From: Zac Denton
Sent: 02 February 2018 08:34
To: Karen Parsons
Subject: FW: Dyers Croft, Main Road, Yapton - Y/89/17/L

RE: Dyers Croft, Main Road, Yapton - Y/89/17/L

I am writing in response to the 'ADC Planning Consultation' statement. The statement suggested that the proposed garage/store in replacement of the existing carport would be visible from the public realm. Would it be possible to find out which part of the public realm the proposed will be visible from?

ELEVATIONS 1:100 @ A1
PROPOSED

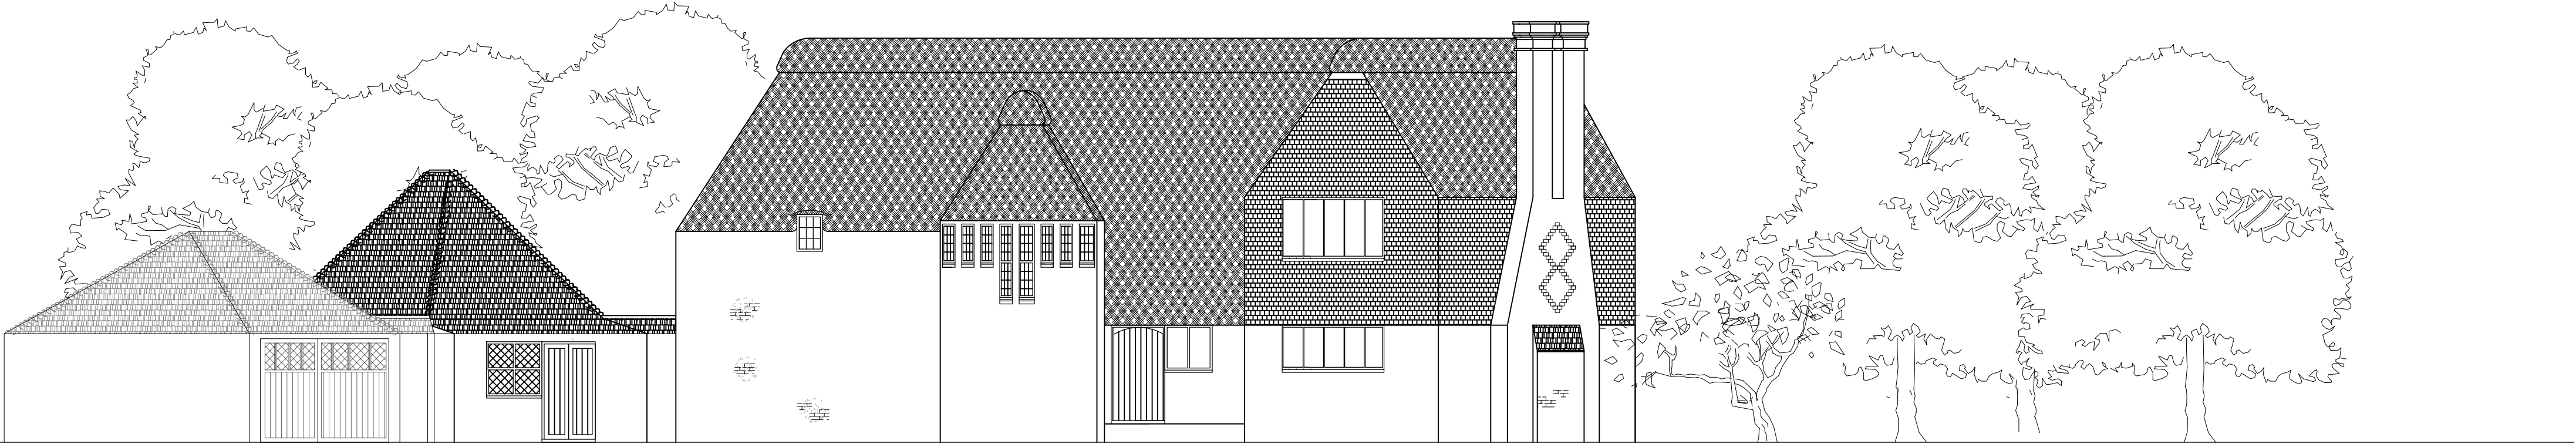
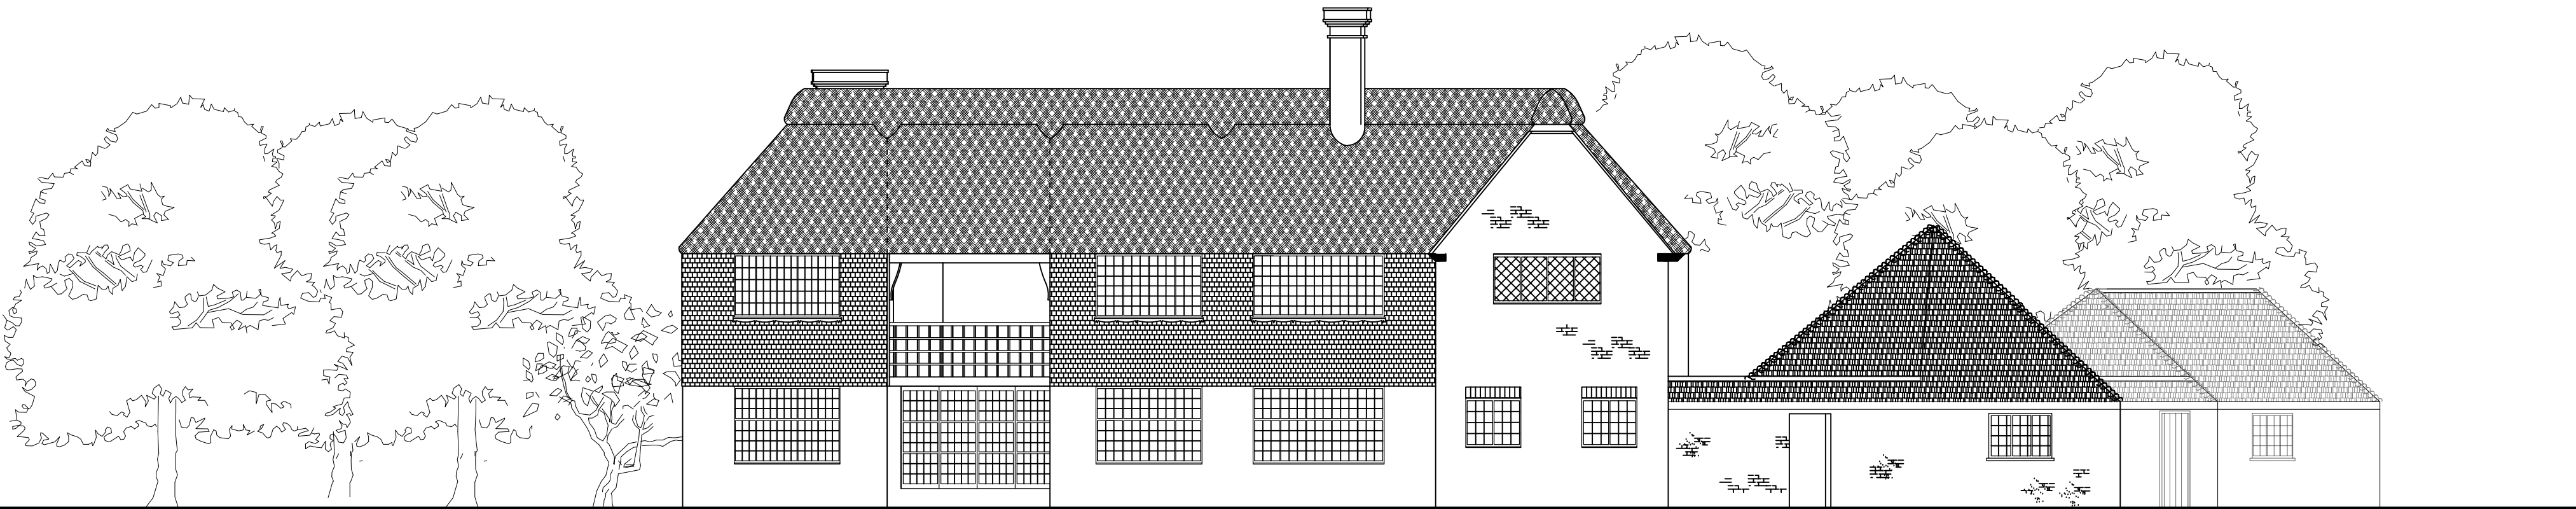
In the 'ADC Planning Consultation' statement, it is suggested that it is unclear as to which element of existing the proposed garage/store materials will match. The Design and Heritage Statement (page 9/16) states that the materials will be as follows:

To clarify the roof tiles will match the adjacent existing store's clay plain tiles. The walls will be painted brick with, four courses of black from ground level and white to eaves, this will match both the existing store and main house as they are both the same, creating a seamless link between the existing and proposed. The garage door will also match the adjacent existing store's oak doors.
